Subject: RE: Further Information Required on Your Ref: PP-06776872 Our Ref: LU/87/19/HH

I have taken over the validation of LU/87/19/PL, 7 Thorncroft Road, for a new dwelling.

LOCATION PLAN

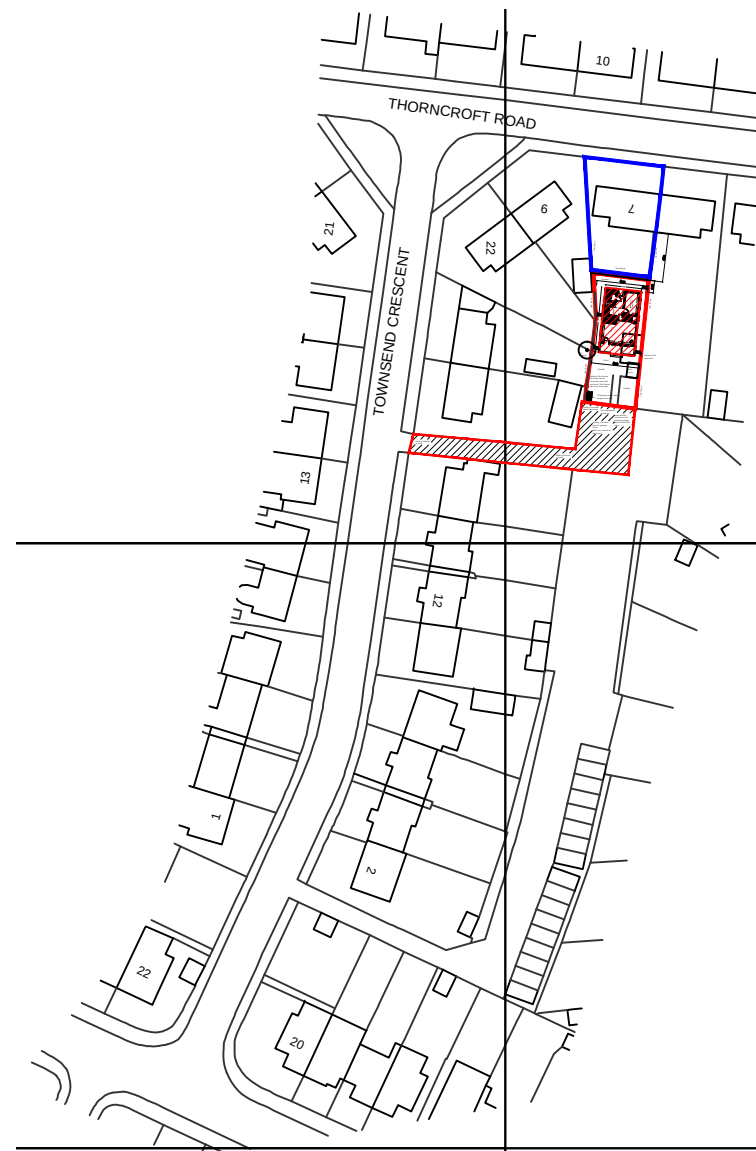
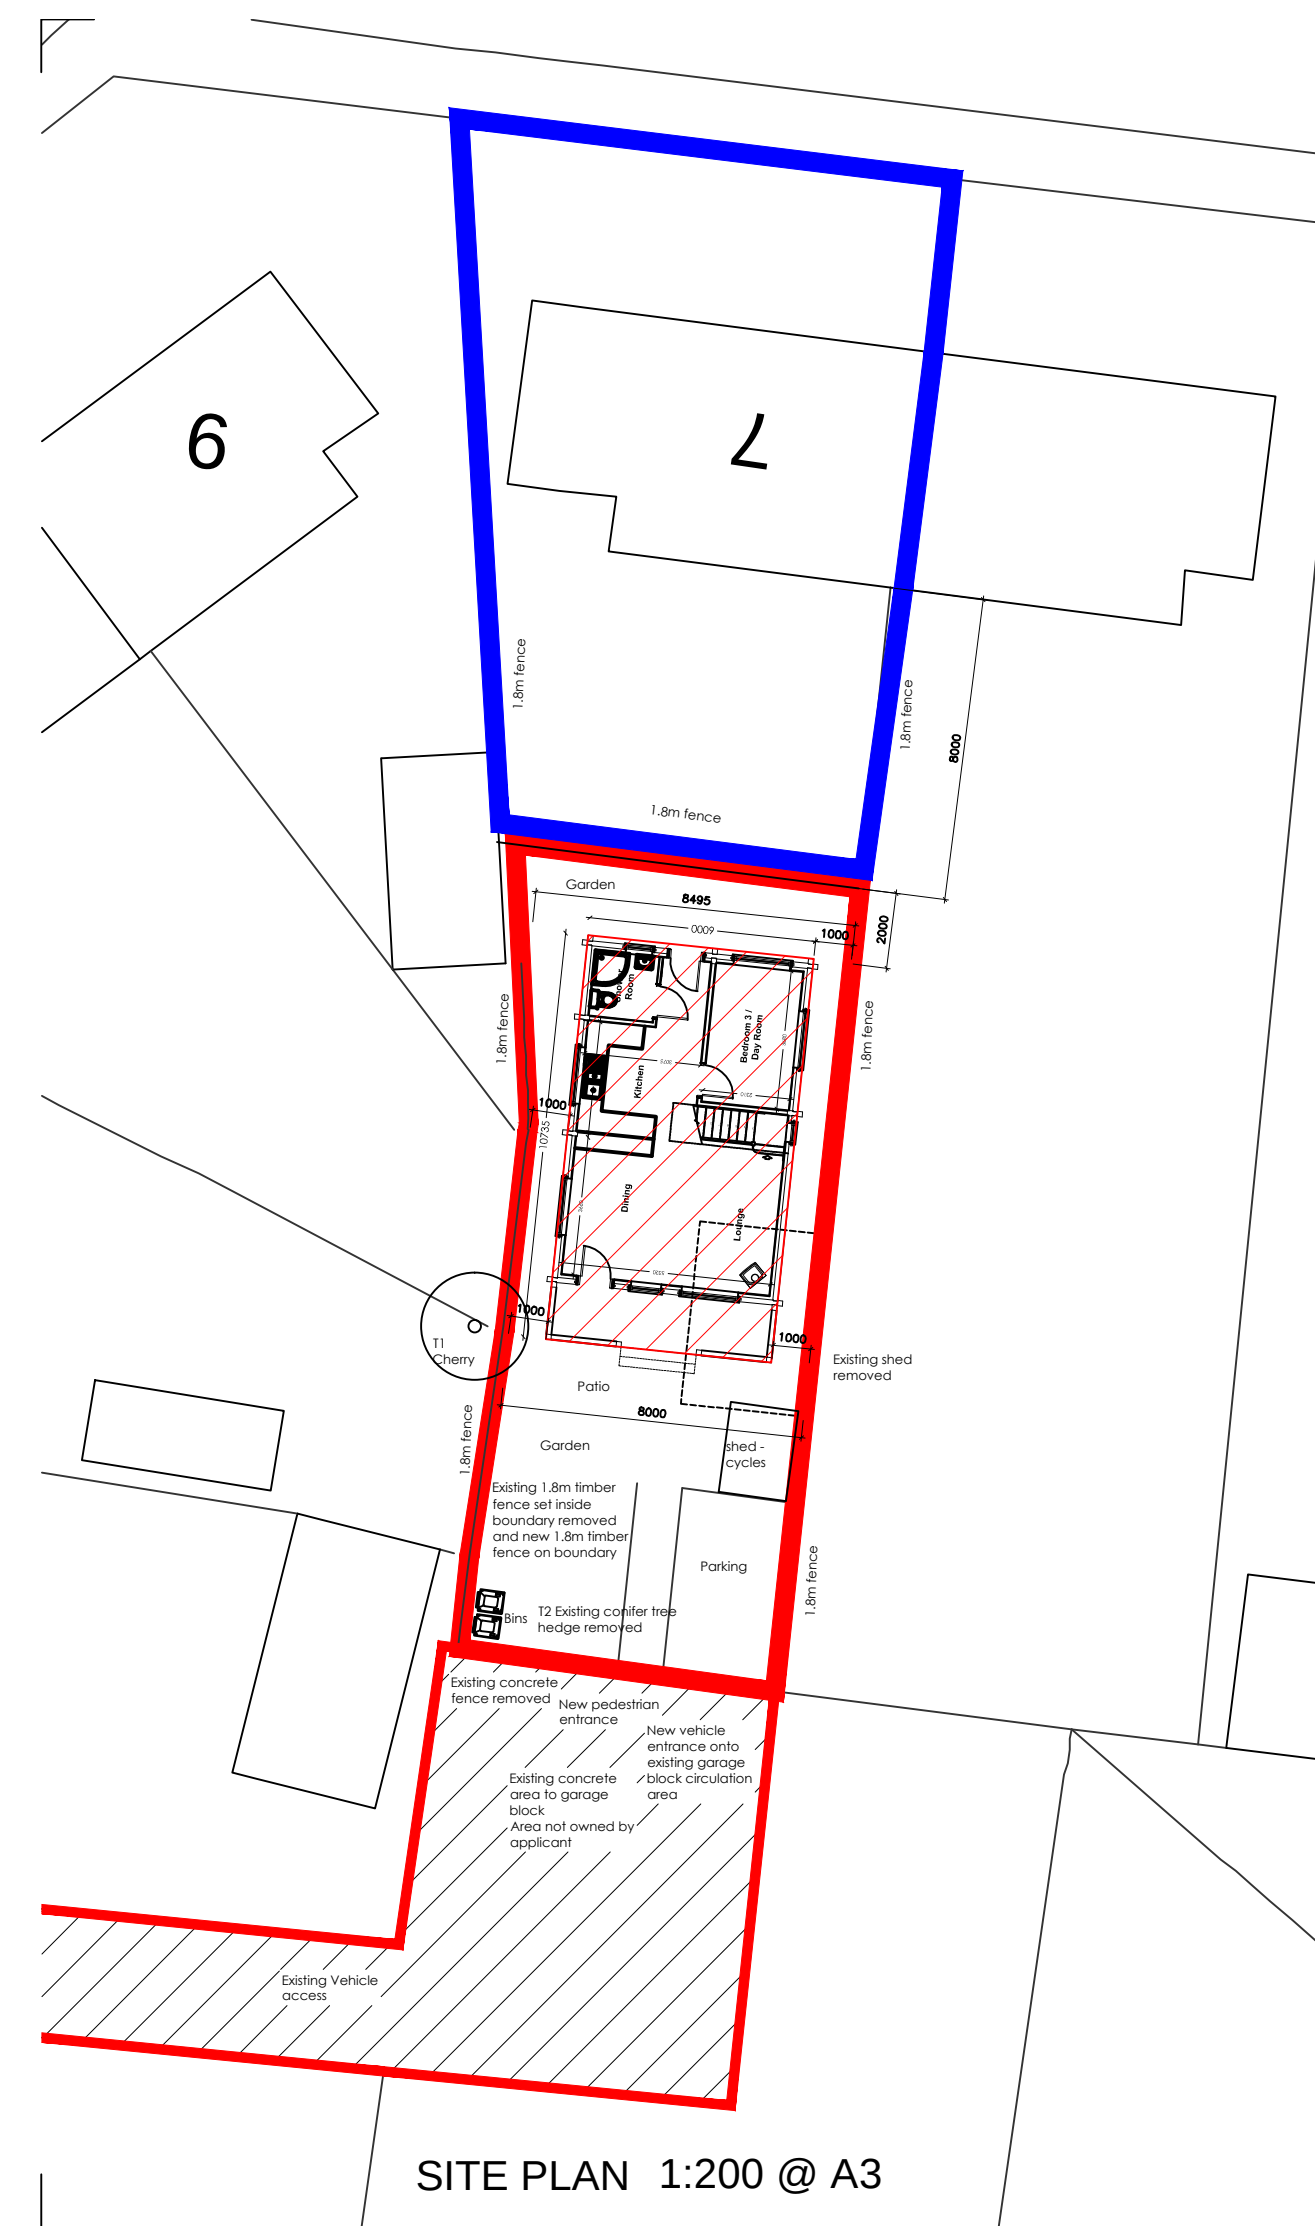
1. I am not sure if you are aware but all the plans you submit will form part of the planning permission if it is approved and you will have to build exactly to the plans. You have only roughly drawn the new dwelling and red and blue edges these need to be accurately drawn as we will measure from these plans.

2. The blue edge needs to be drawn onto the Location plan (1:1250 scale) not the block plan, (1:500 scale)
3. I am sorry but the access you have indicated is not correct. Basically the red edge would need to be extended to be around the area you have shown as hatched as the red edge must go up to the public highway. It is fine to hatch it to indicate it is the access, but it must be within the red edge and there should be a key indicating that the hatching relates to the access and indicate whether it is a vehicular or pedestrian access. If vehicular you will also need to show visibility splays which must also be incorporated into the red edge. If you require guidance on visibility splays you will need to contact West Sussex County Council Highways. The only contact name I have for this is

BLOCK PLAN

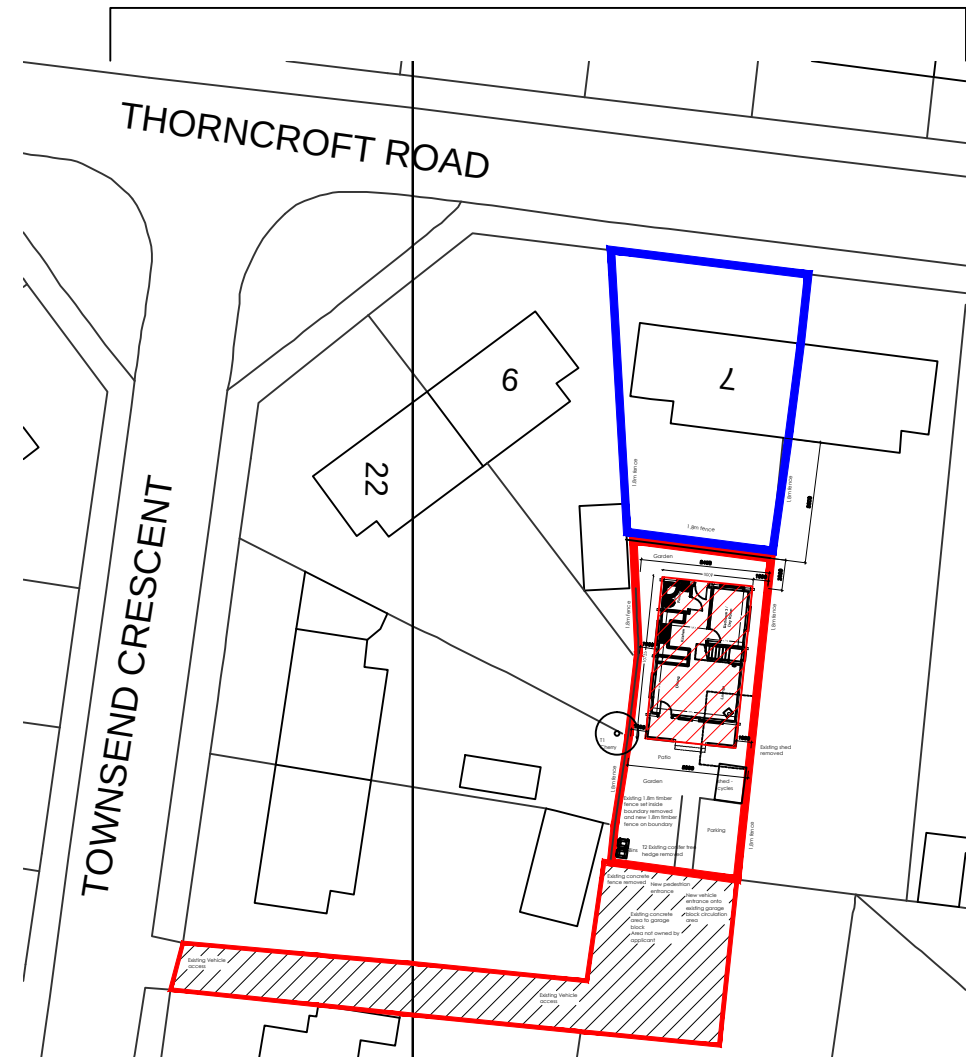
1. A full planning application form (I understand that you have been speaking to Miss Spencer about this and the certificates)
2. A bin statement
3. On the block plan, please provide visibility splays

4. From the block plan it would appear that the visibility splays would encroach onto the properties either side of the drive way to the garage compound so you will need to complete Certificate B on the application form and return it to me and serve notice to both properties. I attach a certificate for you to complete and

Copy of notice 1 served on Arun council for access over private car park owned by Arun council. As this is private visibility splays not required.

Shed added to plans for cycle storage.

Space for bins shown on plans
